Hudson Minor Subdivision, MS-18-002

Please accept the following comments from El Paso County Public Health regarding the minor subdivision project referenced above:

HUDSSON MINOR SUBDIVISION

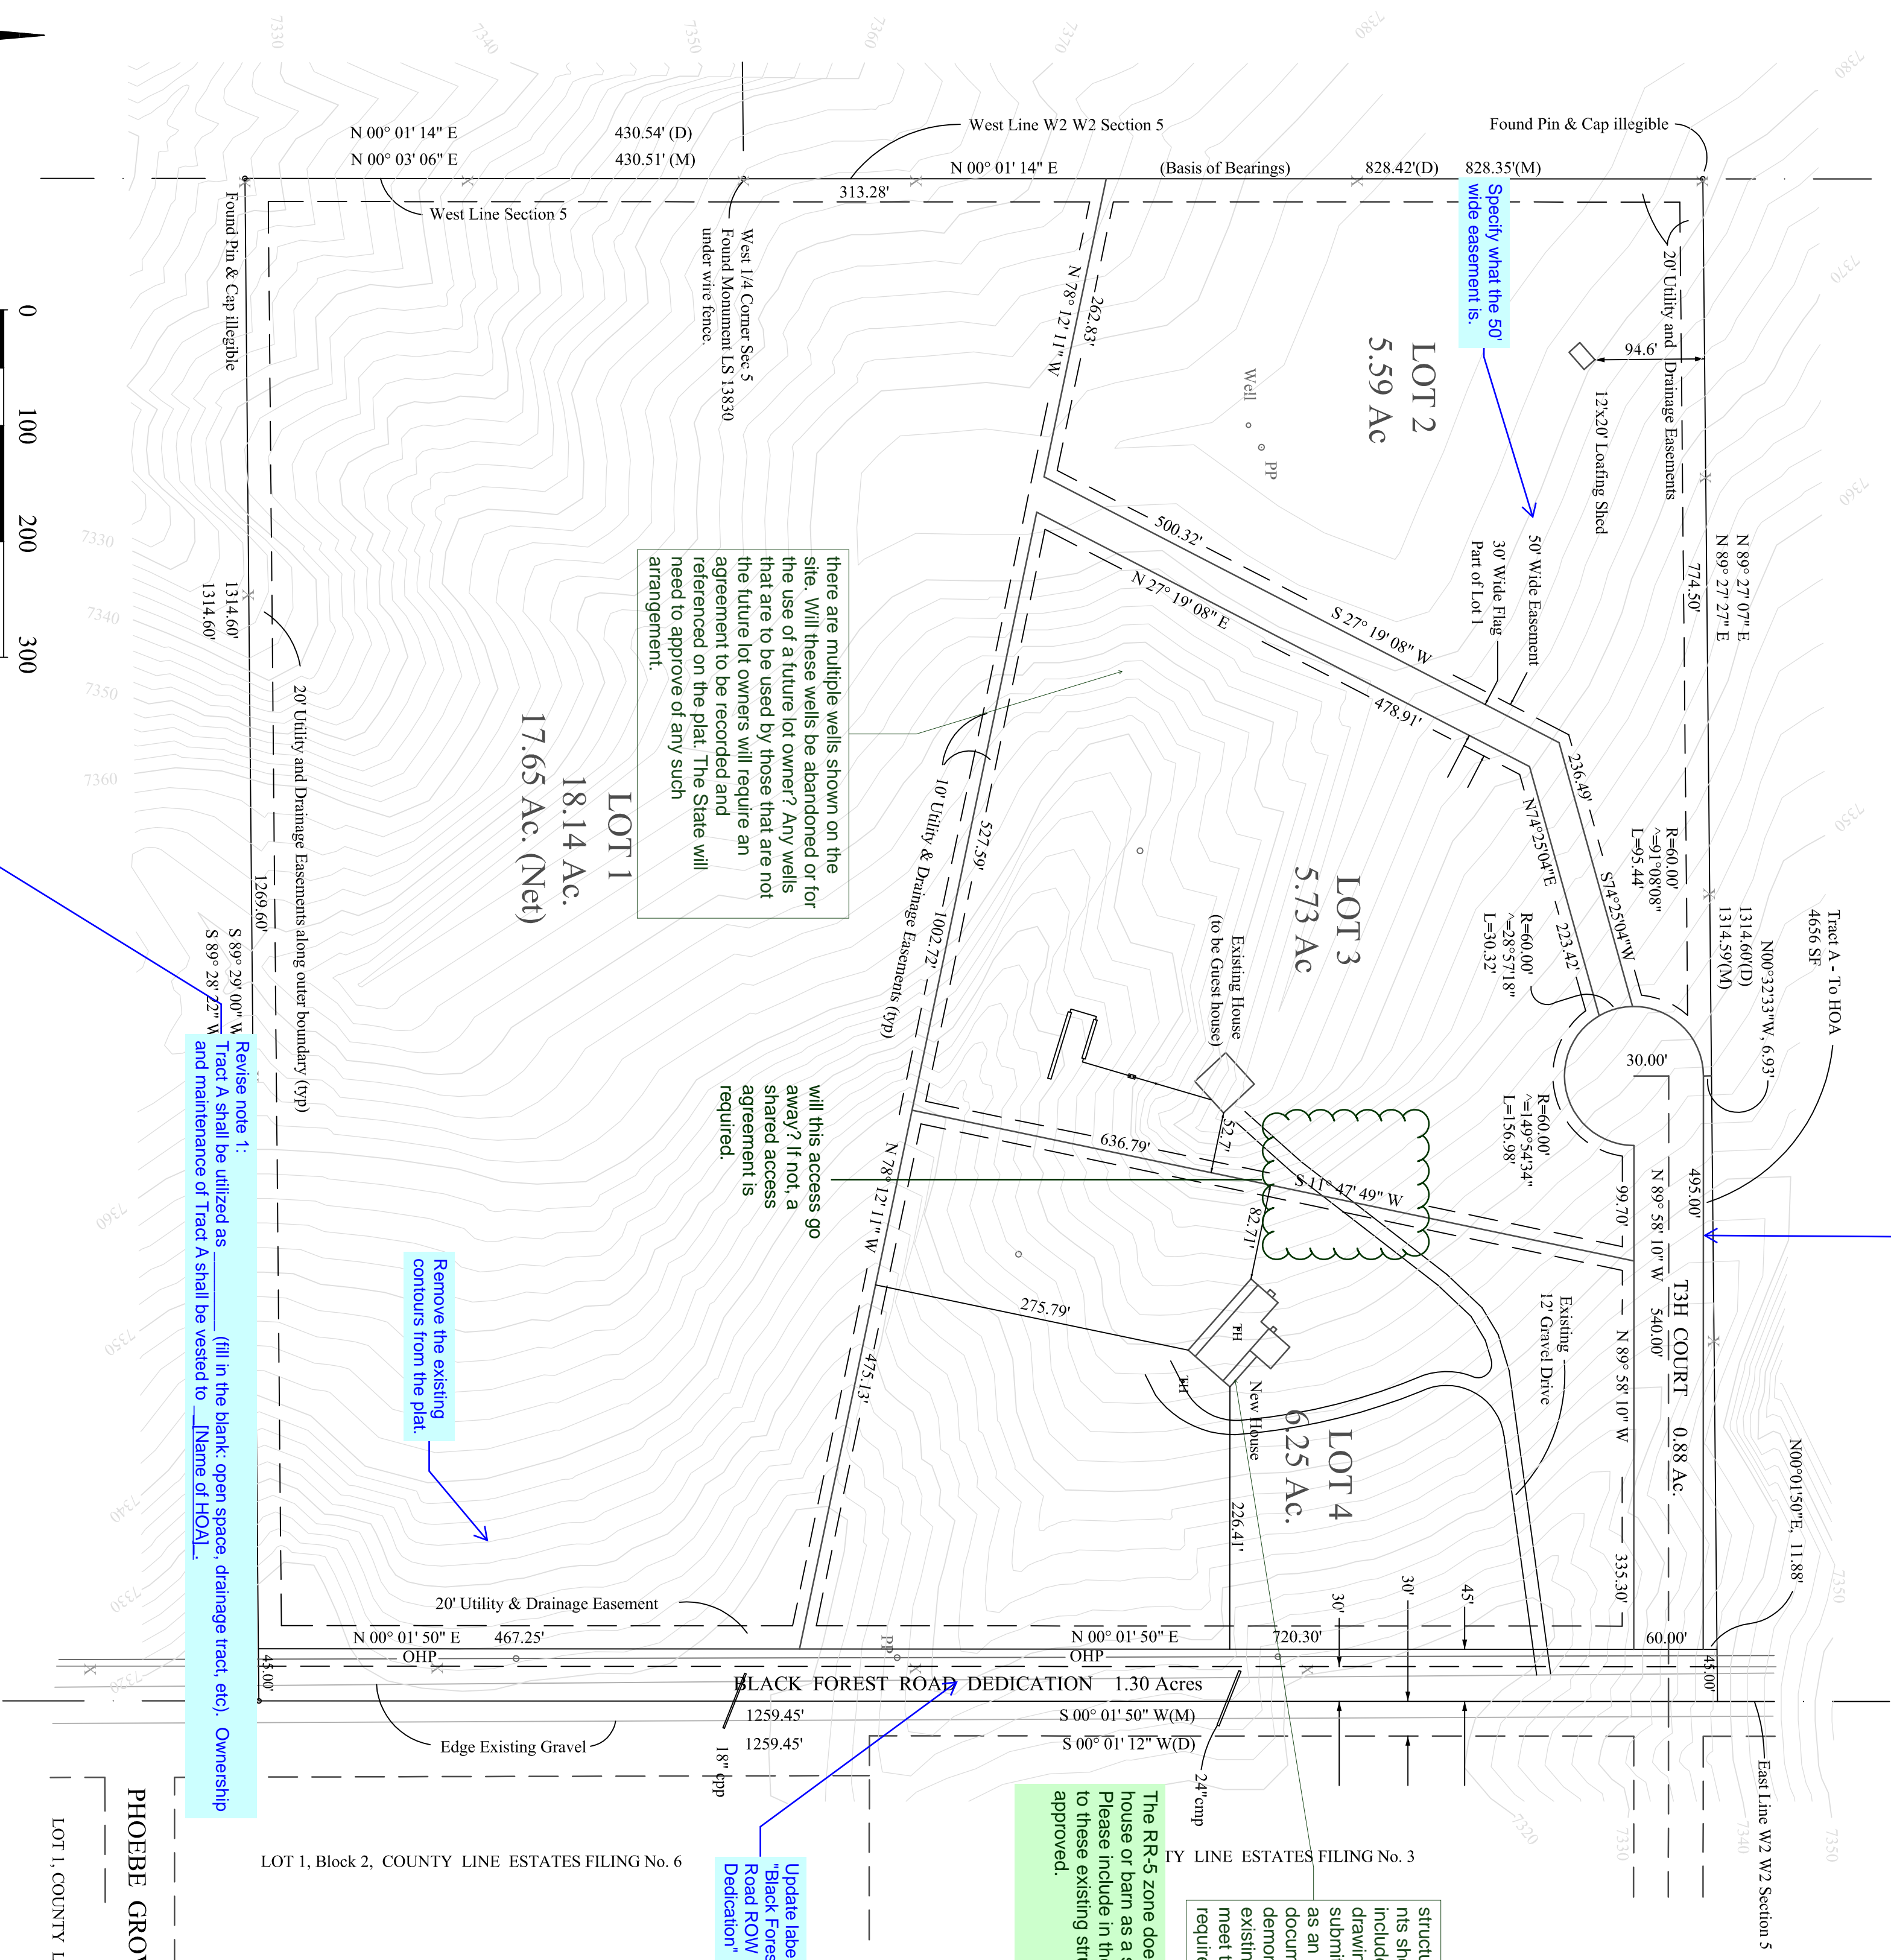
- Proposed new Lot #3 has an existing house constructed in 2004. The house is served wastewater treatment by a permitted and approved OWTS installed in 2004. The existing soil treatment area (STA) for this OWTS must be 10' minimum from any new proposed lot line. There is also a requirement for sufficient areas to be dedicated for the replacement of this STA should the original area fail requiring an addition or total replacement. The primary and secondary STA's (existing and proposed) must be protected from compaction associated with vehicles and/or livestock.

- The existing well and all new wells must be 100' minimum from any existing or any new STA.
- Proposed new Lots 1 & 2 and the house under construction on proposed new Lot 4 require full compliance with the El Paso County Board of Health Regulations, Chapter 8, Onsite Wastewater Treatment Systems.
